**DEVIATION REQUEST
AND DECISION FORM IN
ASSOCIATION WITH A
REQUEST FOR A PUD
MODIFICATION FROM
THE ECM**

A deviation from the standards of or in Section **ECM 2.3.8 .A** Engineering Criteria Manual (ECM) is requested.

Roadway Terminations

PUD SITE PLAN

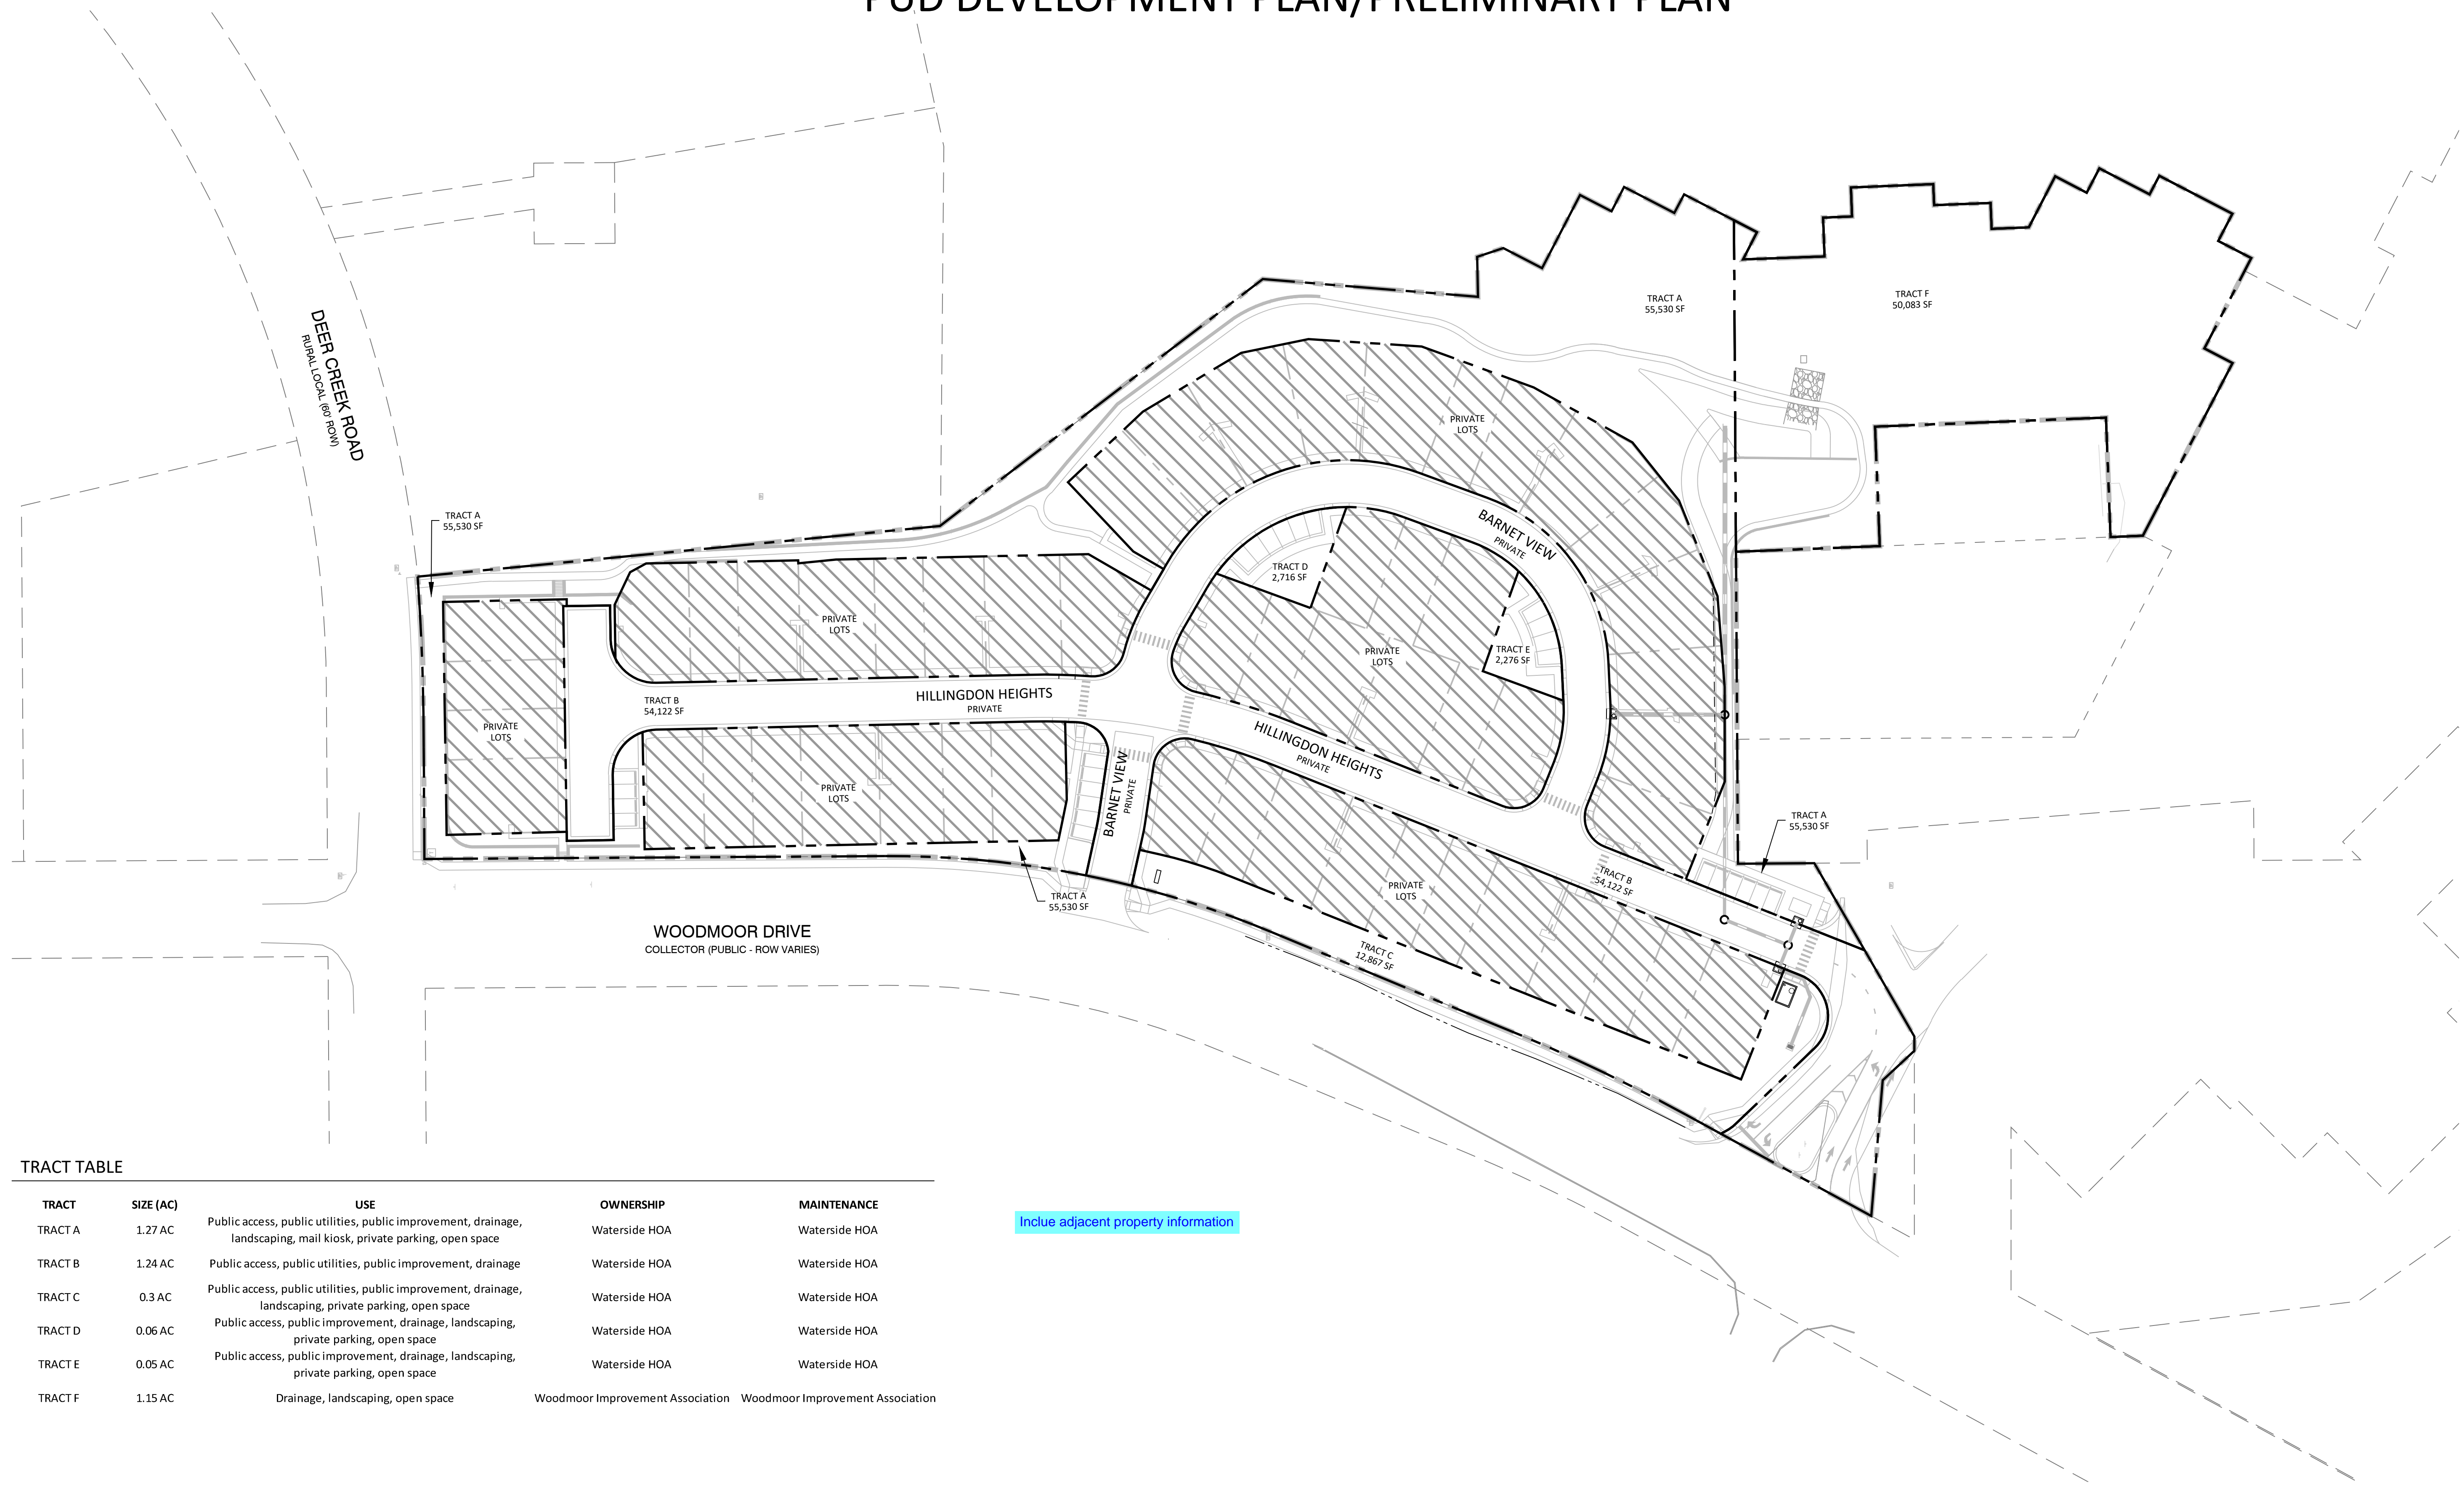
Provide exhibit to show roadway termination.

**Where is the second turnaround?
Only see one on development plan.**
